**CITY OF MERCER ISLAND**

June 9, 2017

Re: First Review Letter CAO17-004/SEP17-009  
7880 SE 80<sup>th</sup> PL Mercer Island, WA 98040; Parcel ID: 536800-0300

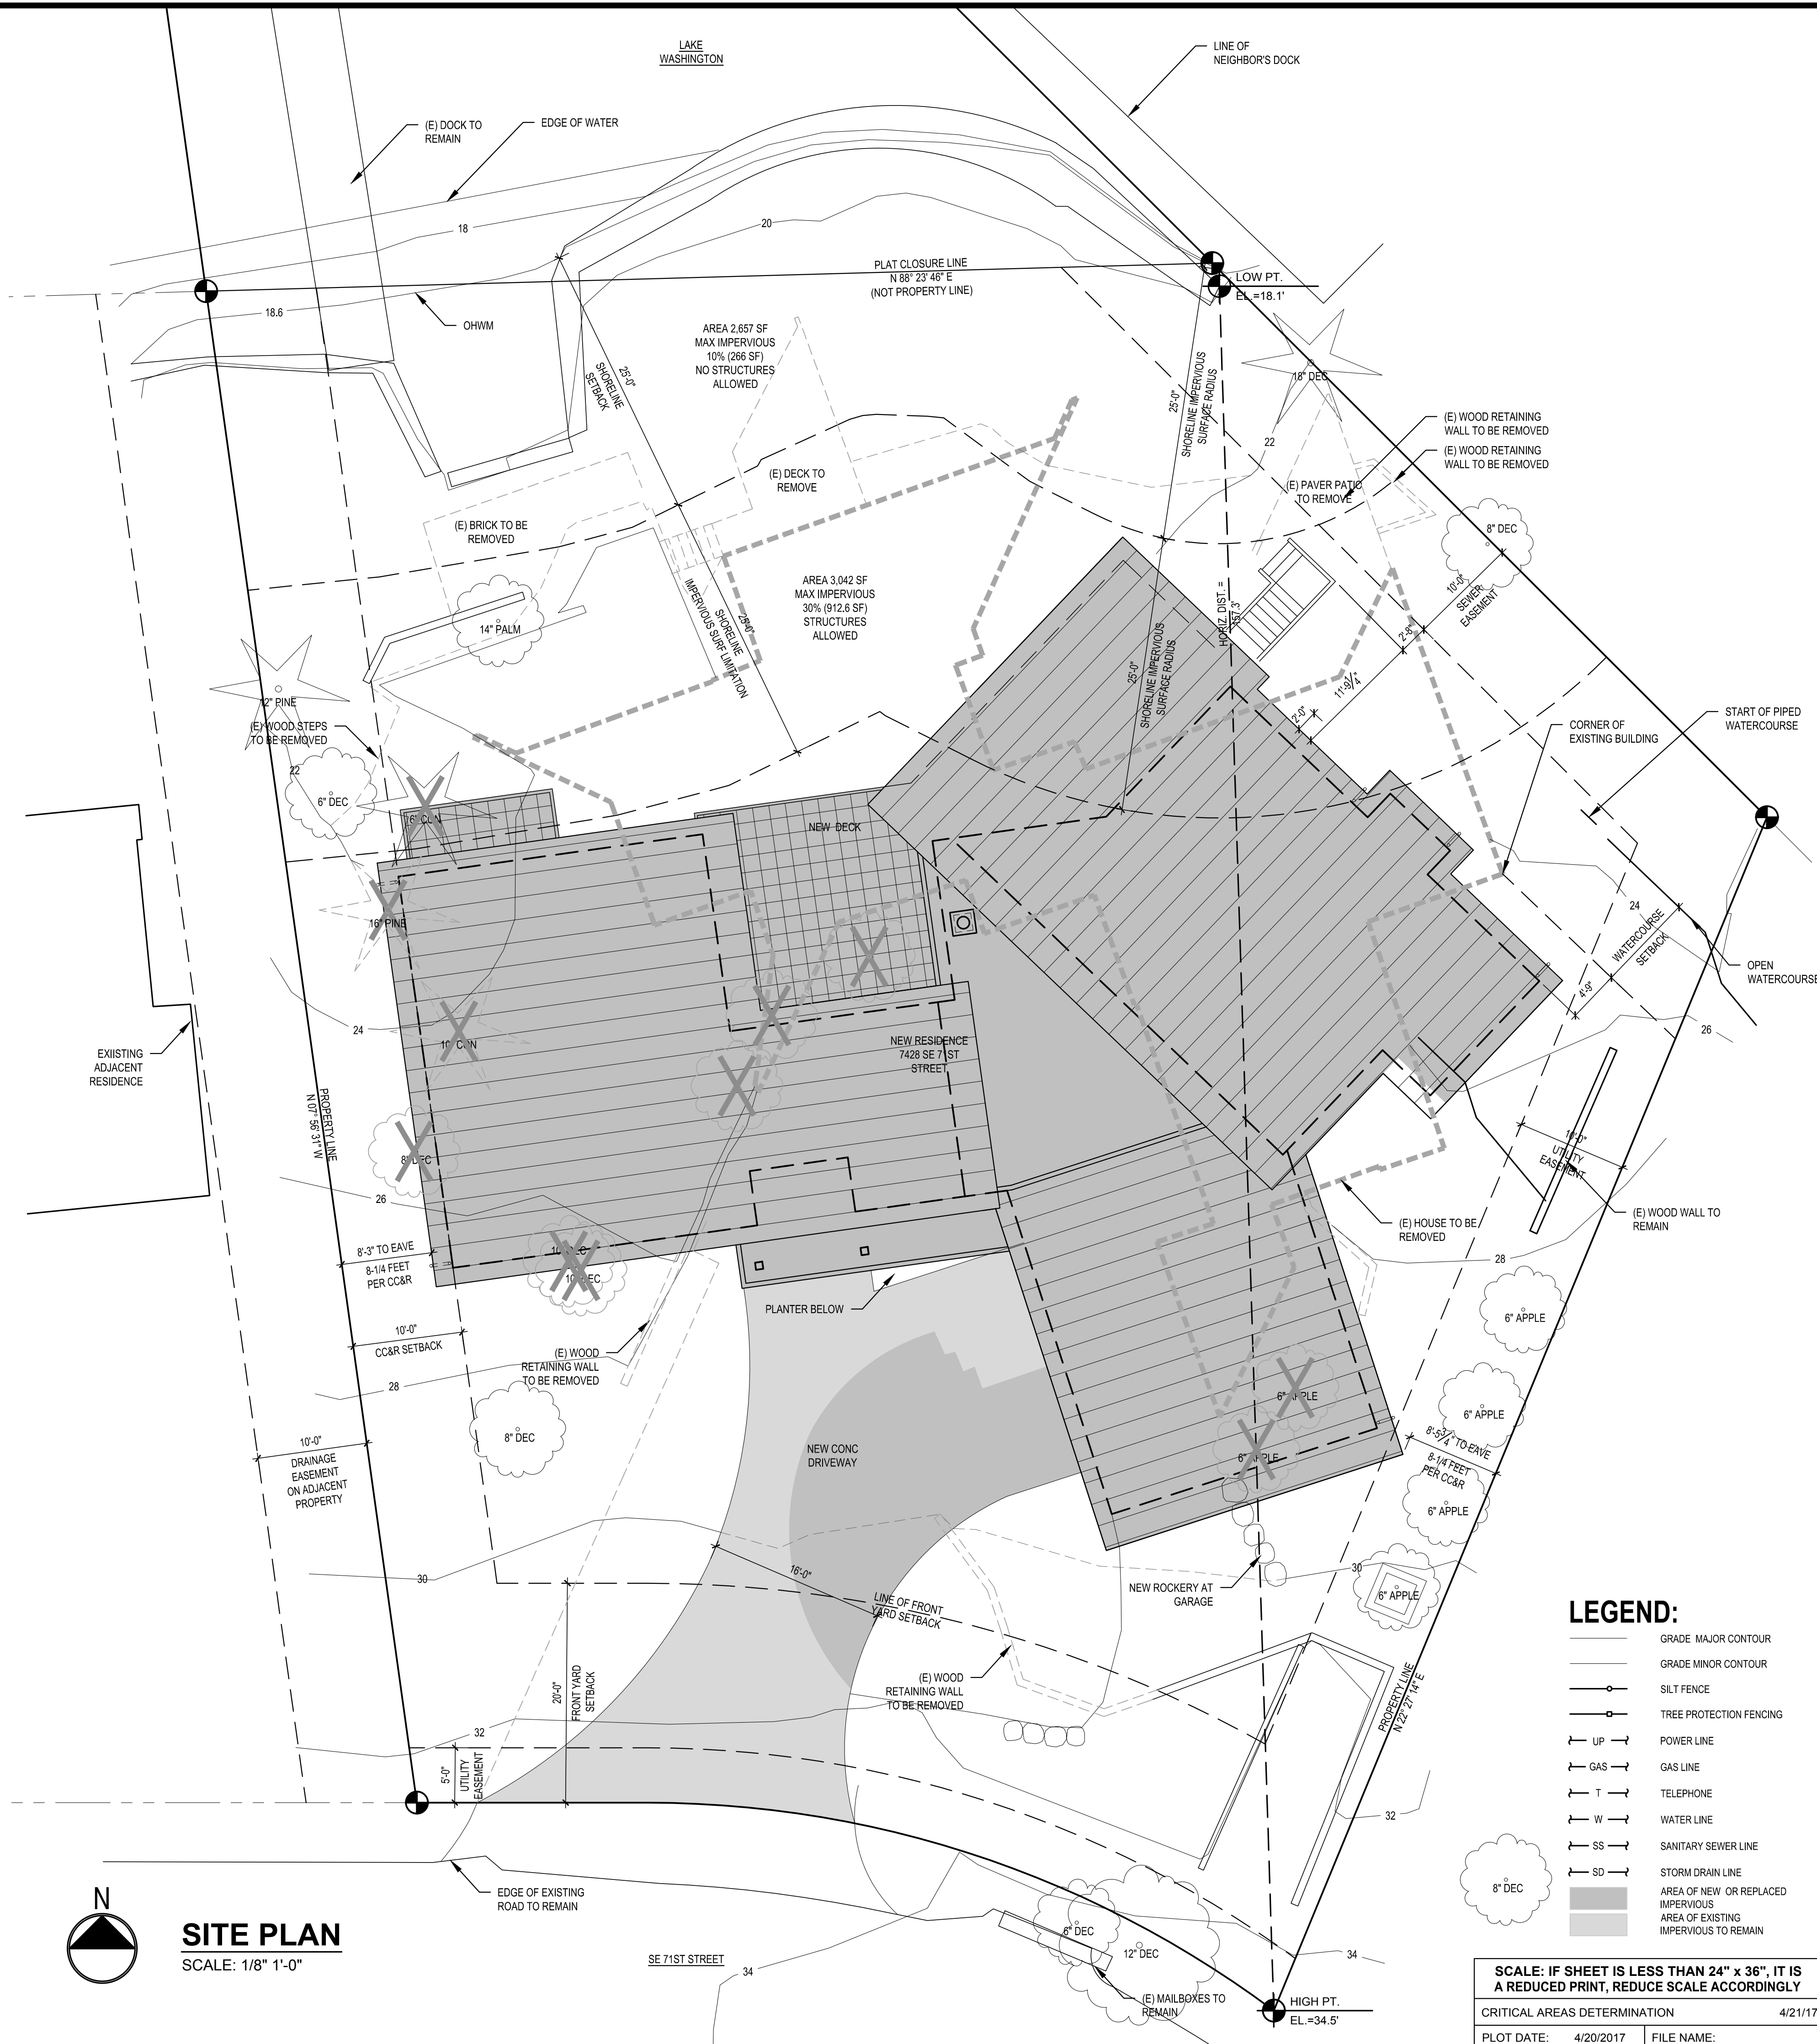
1. Please clearly indicate what the proposed buffer reduction is for the piped watercourse (Watercourse B), and the piped watercourse and open type 3 watercourse (Watercourse A). Following review of the plans it appears that the piped watercourse buffer on the west property line will be reduced from 25 feet to 14 feet. The piped watercourse on the east property line appears to be reduced from 25 feet to 8 feet, and the open type 3 watercourse buffer will be reduced from 35 feet to 10 feet.
